Application Reference: Application 3/2026/0375

Site: Playing Field Edisford Road Clitheroe BB7 3LA

Proposal: Proposed synthetic turf pitch, including fencing, acoustic barrier, floodlighting, access path, toilet block and ancillary equipment.

Sport England Reference: PA/26/NW/RV/74134

STP LAYOUT

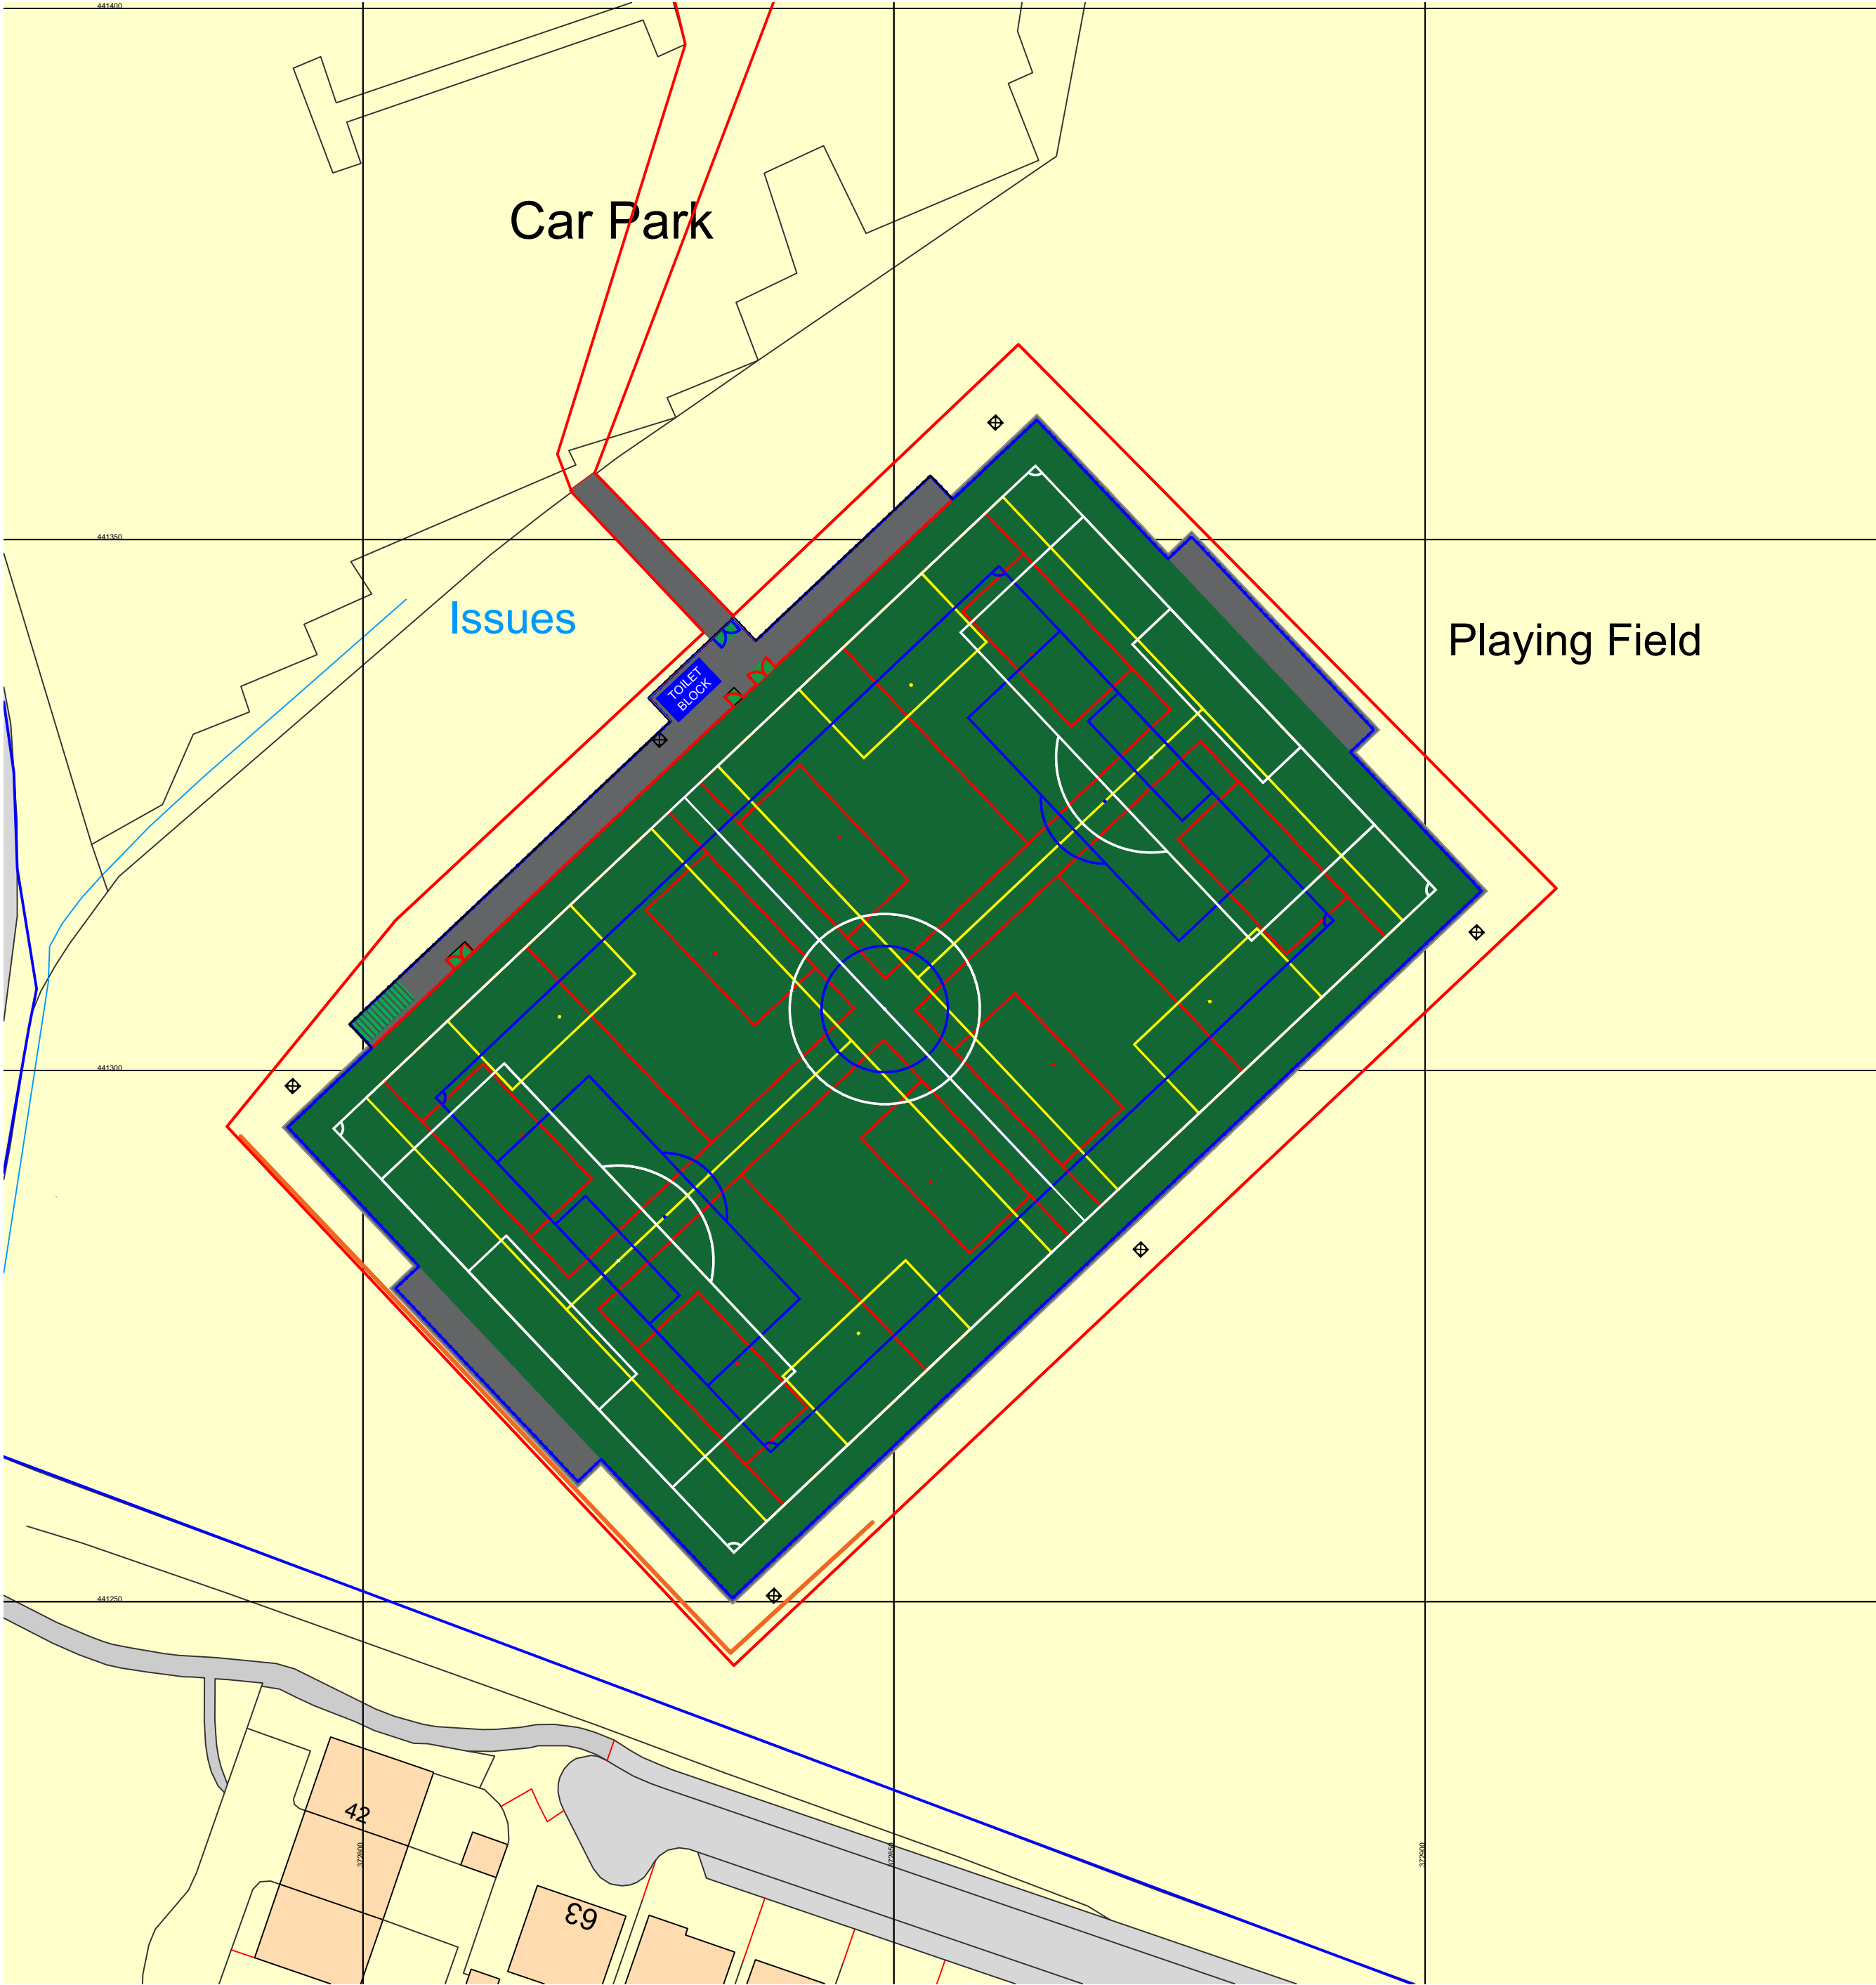
FF notes a small error with the design and access statement highlighting the pitch will have 2x 9v9 however FF follows the other information submitted as the correct layout with only 1x 9v9 configuration due to the size of the pitch being 91x55.

Surface Water Strategy

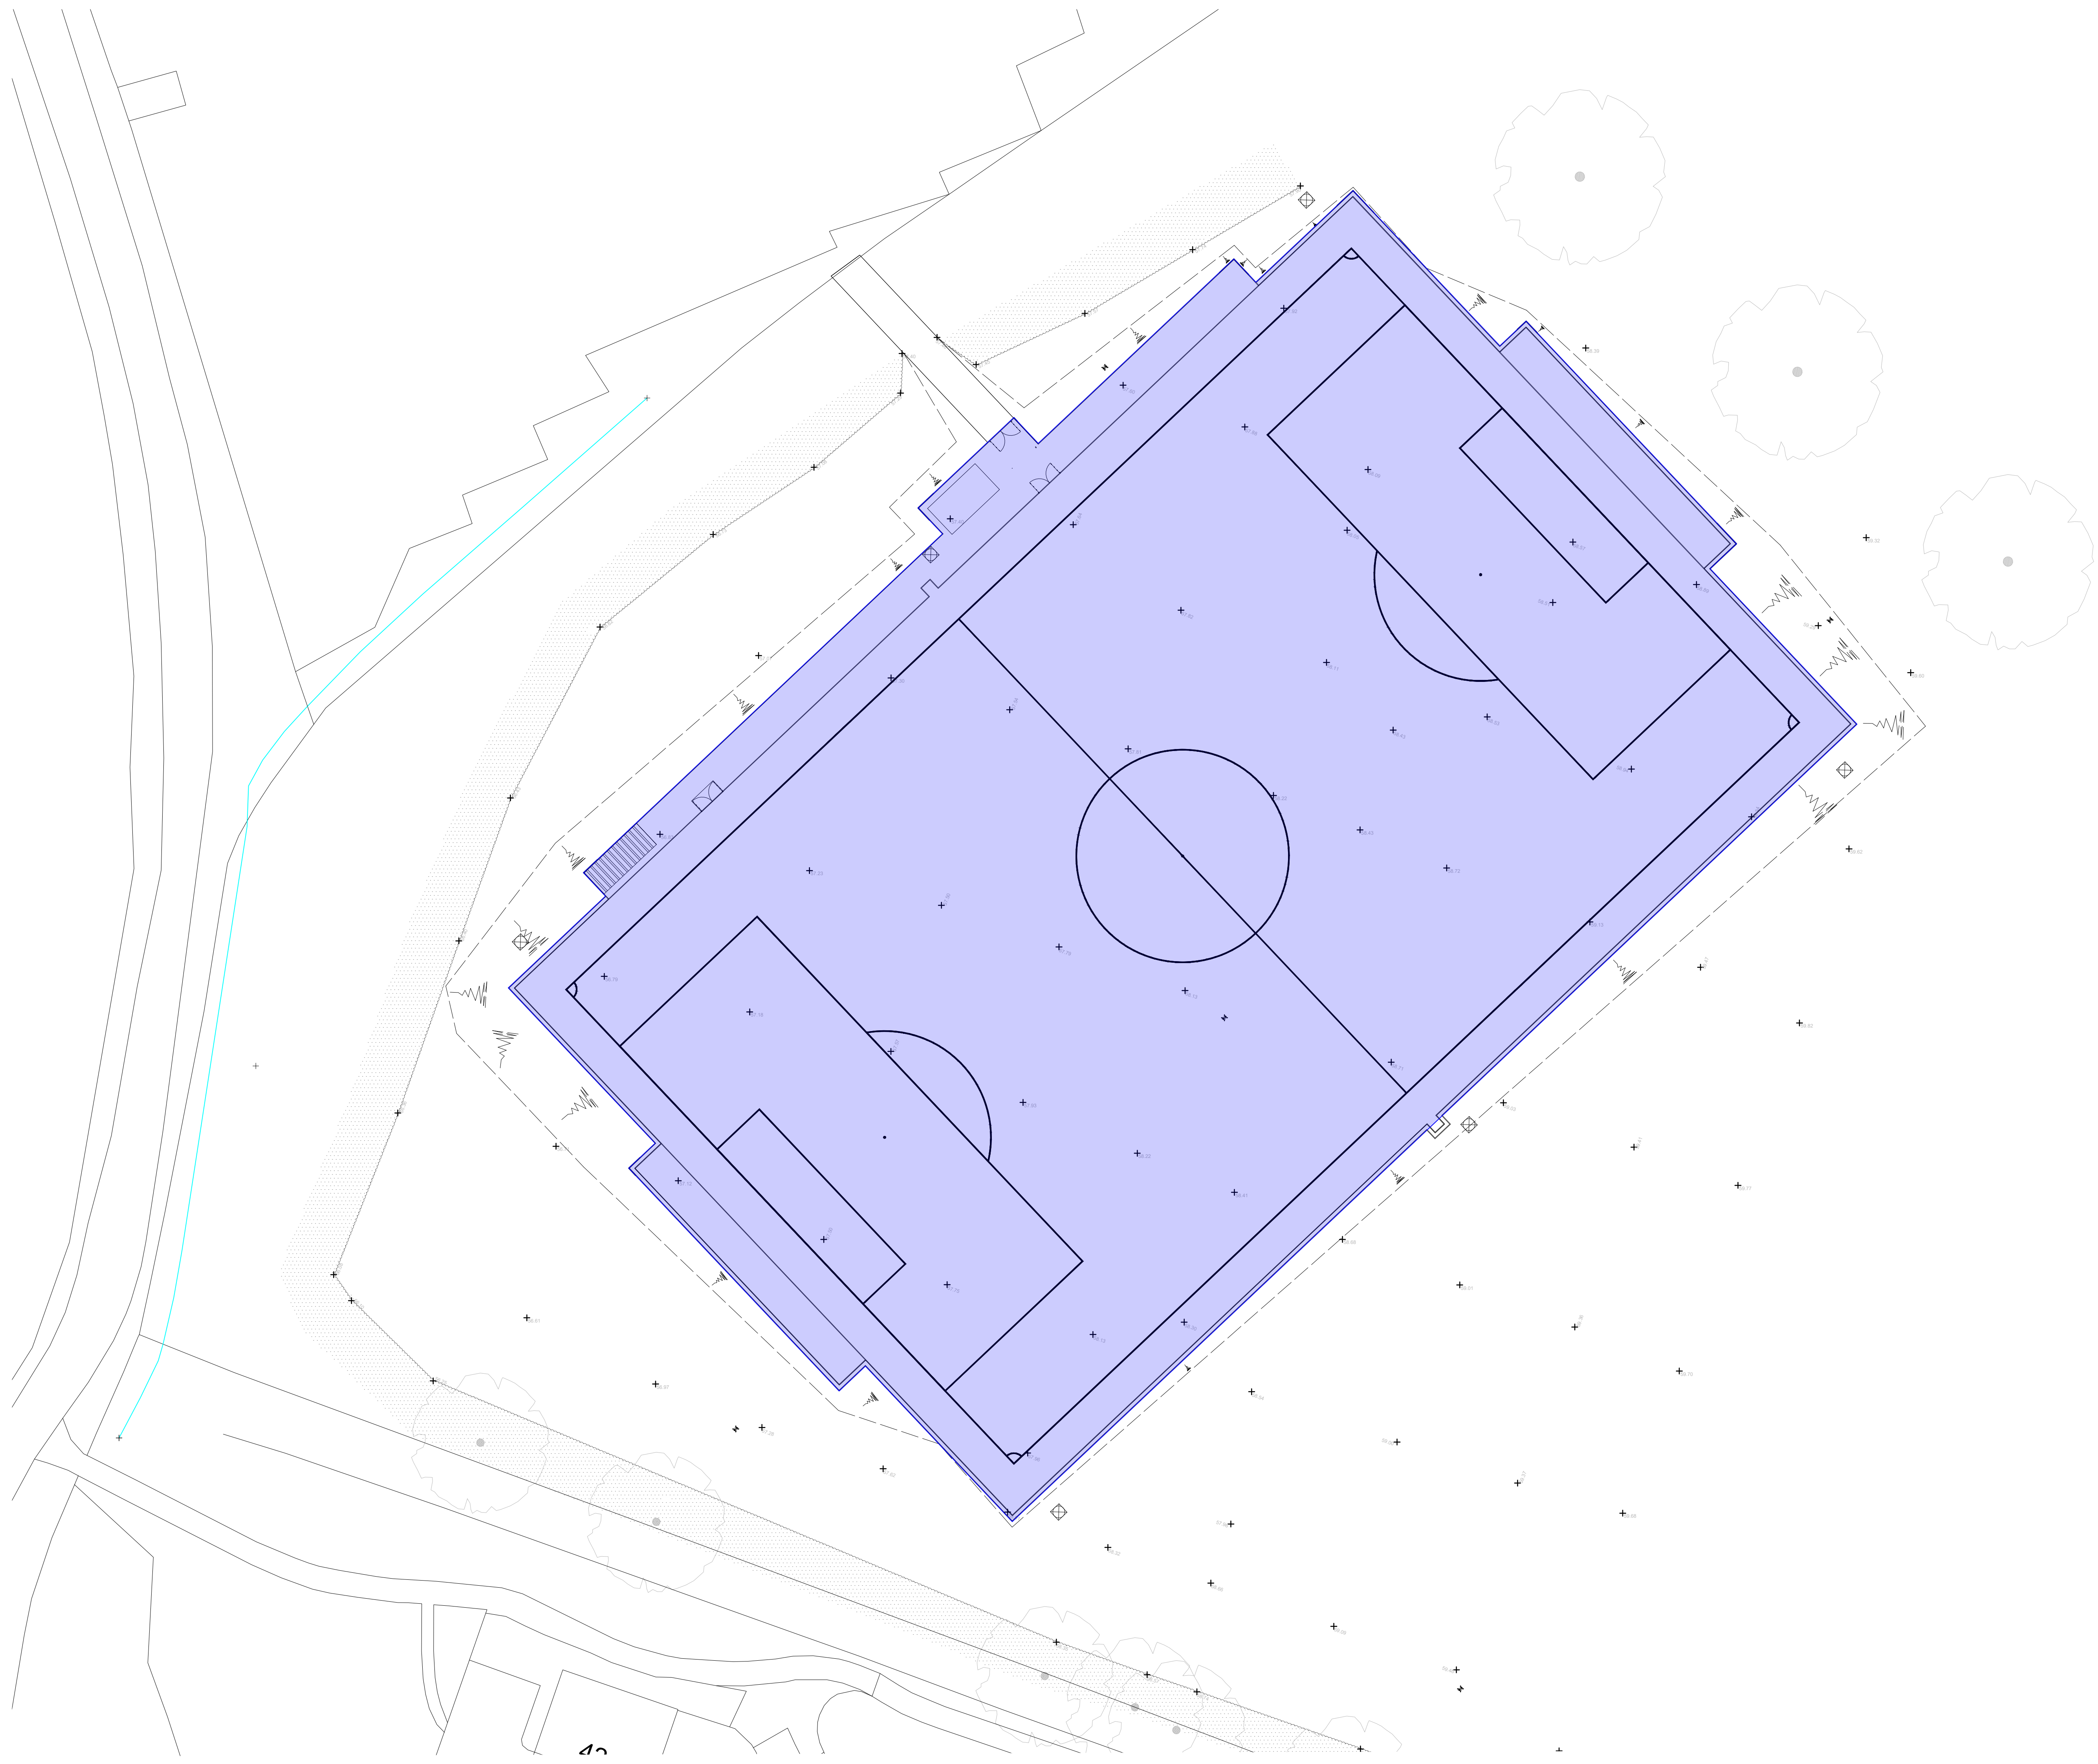
There is a concern that the drainage system is not showing any interceptors to prevent the 3G infill migrating into the environment. This needs to be addressed via condition.

1. No development shall commence until details of the design and layout of surface water drainage details for the artificial grass pitch, to prevent the infill materials entering the natural environment have been submitted to and approved in writing by the Local Planning Authority [after consultation with Sport England]. The surface water drainage system for the artificial grass pitch shall not be constructed other than in accordance with the approved details.
